City of Portland
 Development Review Application
 Planning Division Transmittal Form

Application Number: 2014-098 **Application Date:** 06/03/2014
CBL: 326 B009001 **Application Type:** Level III Site Plan Under 50,000 sq f
Applicant: Allagash Brewing - 50 Industrial Way, LLC
Project Name: Allagash Brewing Expansion
Address: 50 INDUSTRIAL WAY
Project Description: 2,400 Sq Ft Tank Support addition (Bunker), 18,360 sq. ft. Production Exp.
 (connecting 50 & 100 Industrial Way Facilities) adding loading docks and associated site work.
Zoning: IM

**Allagash Brewery - 50 Industrial Way
PB Workshop 7.8.2014**

TO: Barbara Barhydt, Planner
FROM: David Senus, P.E. & Ashley Auger, E.I.T.
DATE: June 19, 2014
RE: Allagash Brewing Expansion, Preliminary Level III Site Plan Application

**DEMOLITION PLAN - PHASE 1**

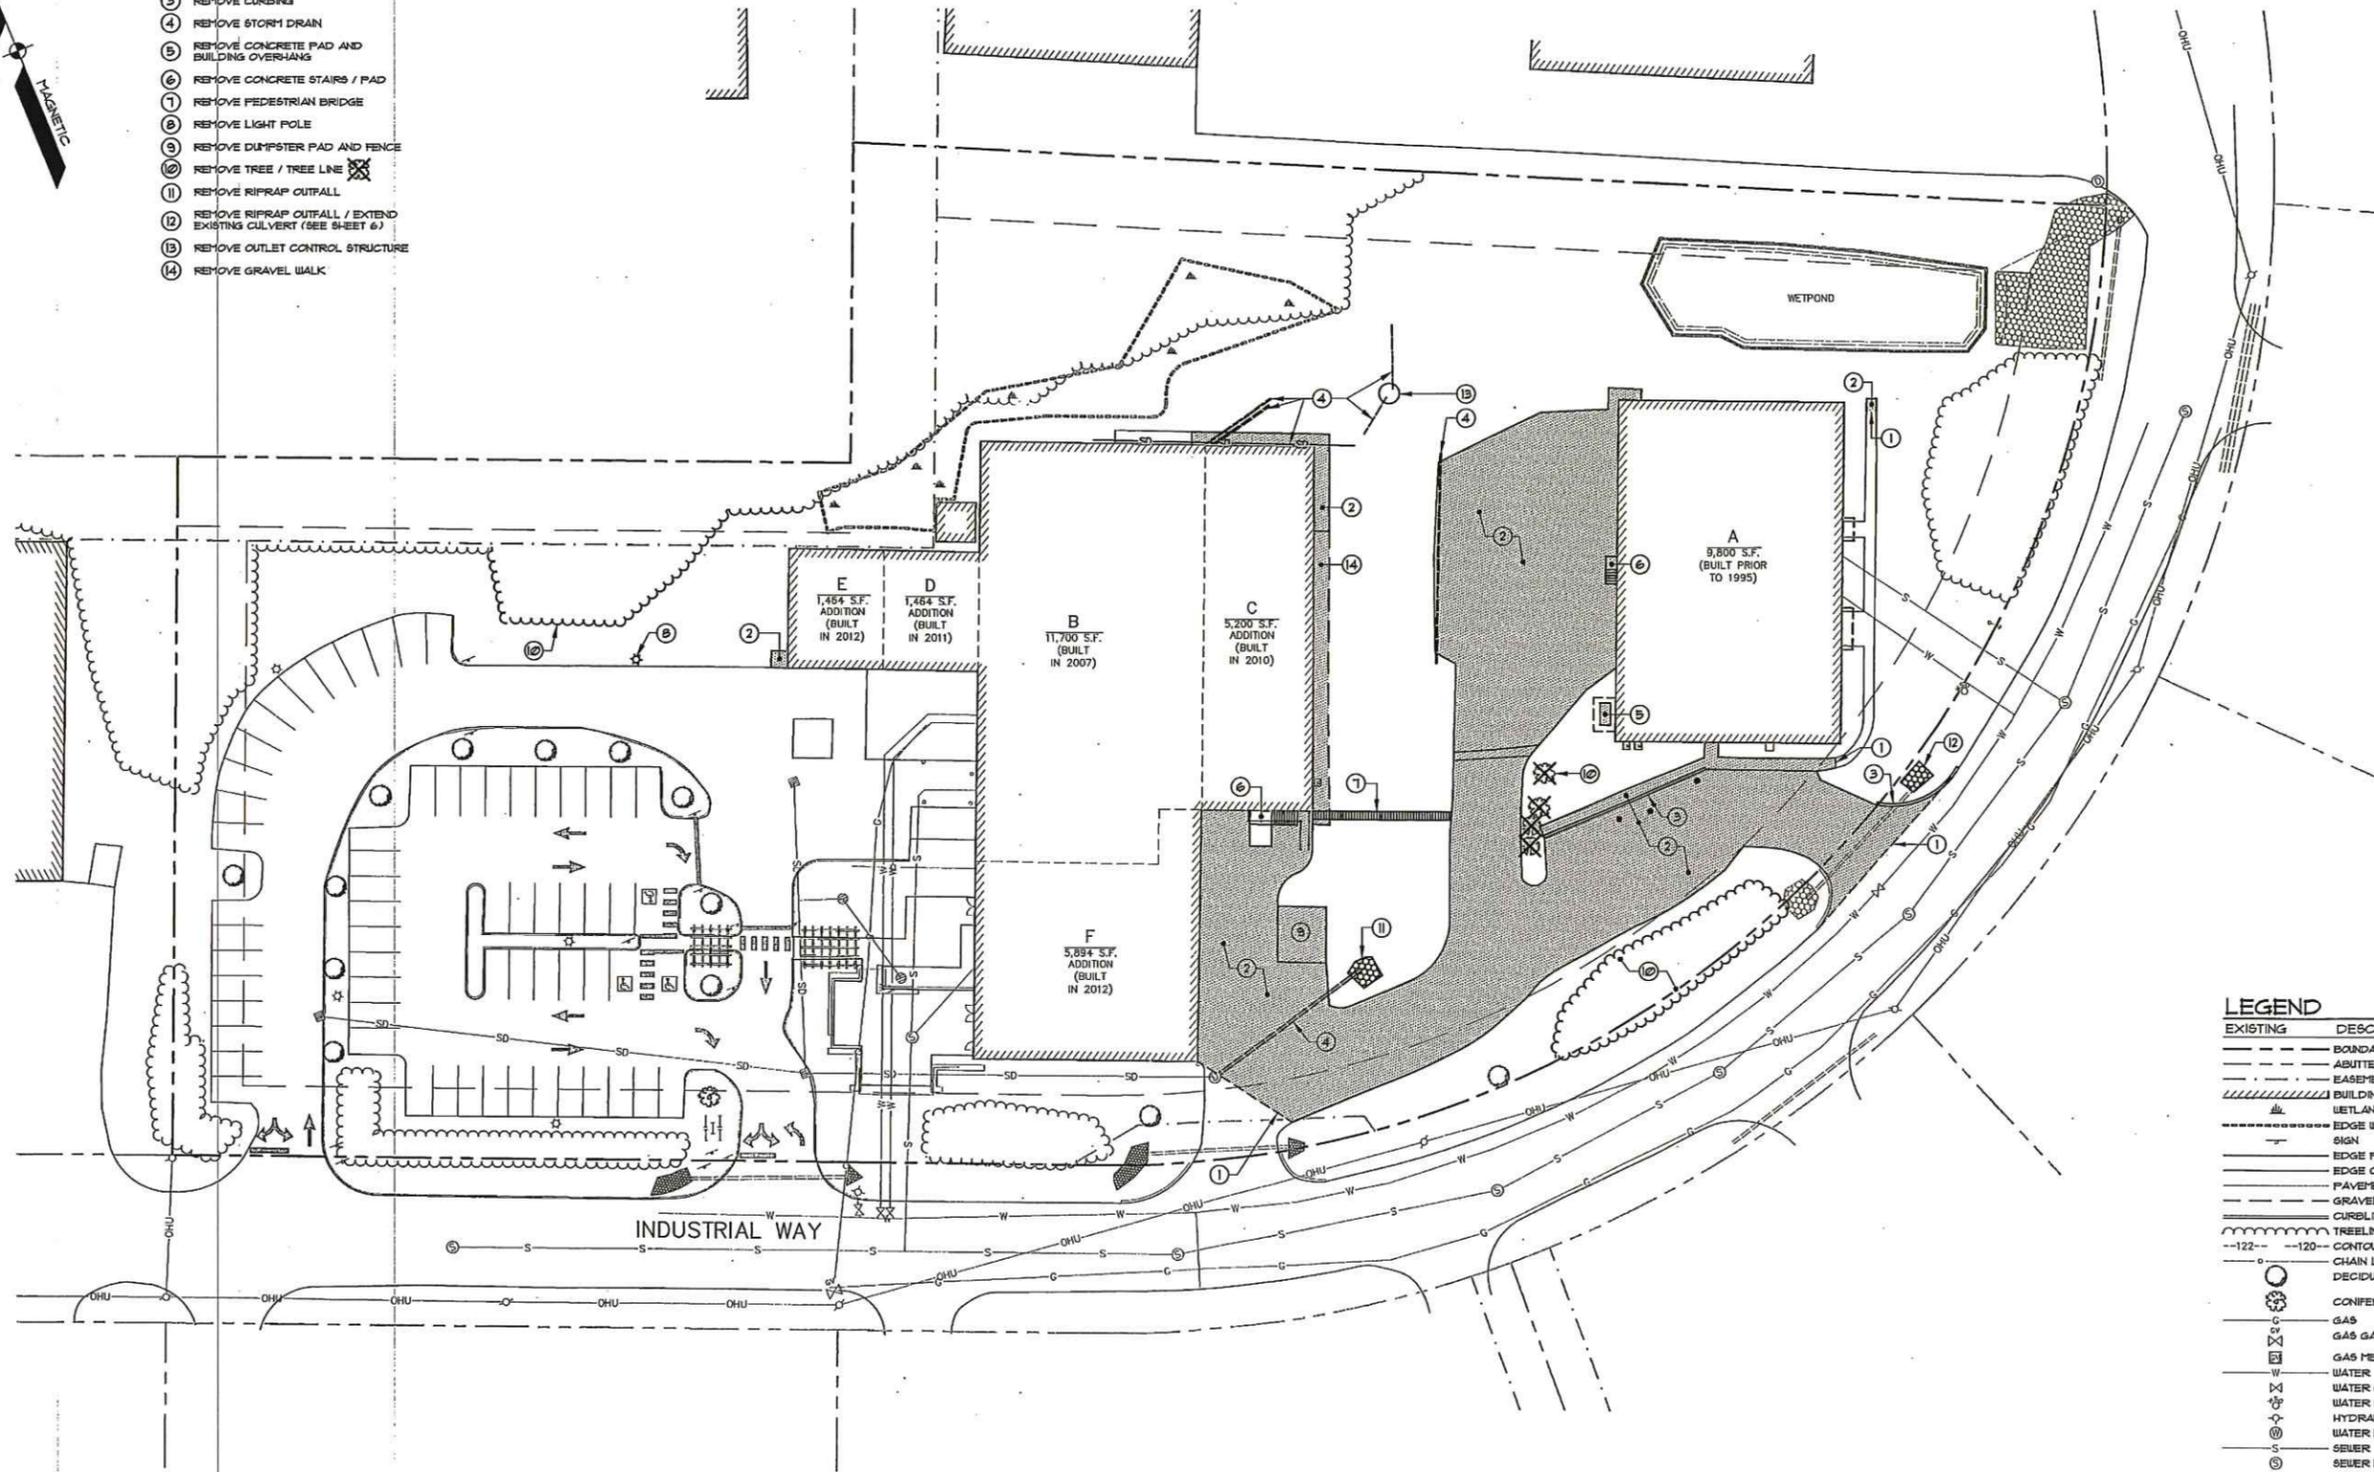
Another question is re the existing trees in the buffer zone- the Demo Plan says specimens to preserve to be identified and the Landscape Plan shows fruit trees- it would help Jeff Tarling (since the buffers have been a big issue since the first review) to know whats intended here.

SHEET: C7.1

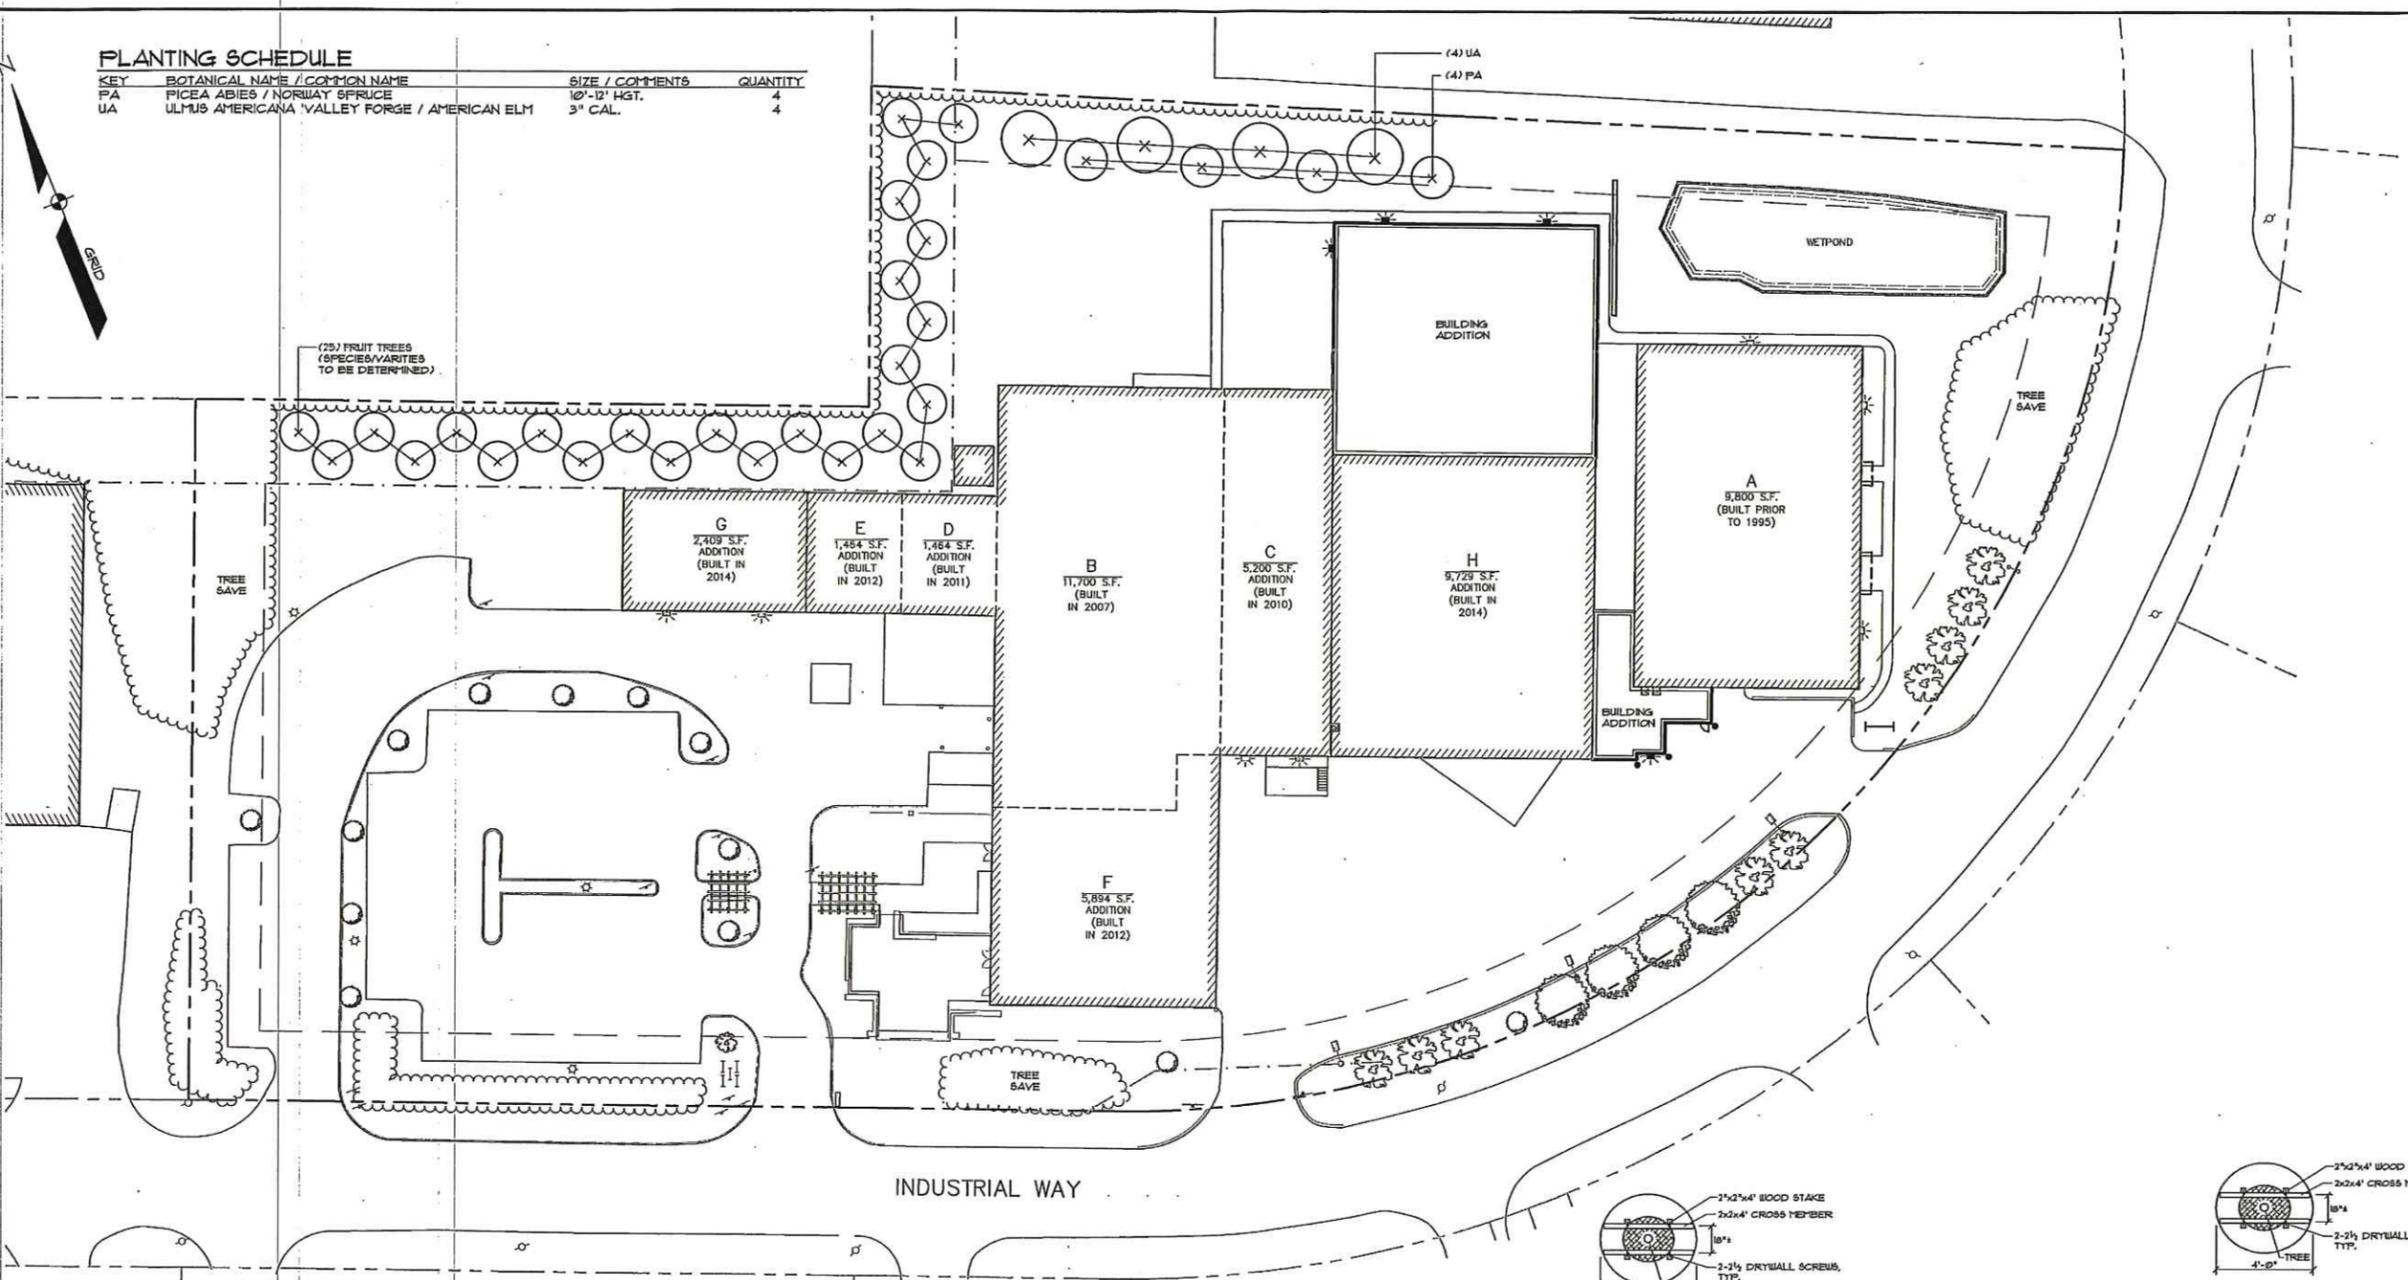
- **Landscaping**: the landscaping plan in Plan P7 does not include landscaping details in the vicinity of the new buildings and concrete slab (which is understood to be for tanks), nor around the proposed detention basin. Further landscape detail, at least for phase 1, is recommended to be added to the final submission; the phase 2 landscape details could be part of the conditions relating to phases 2 and 3.
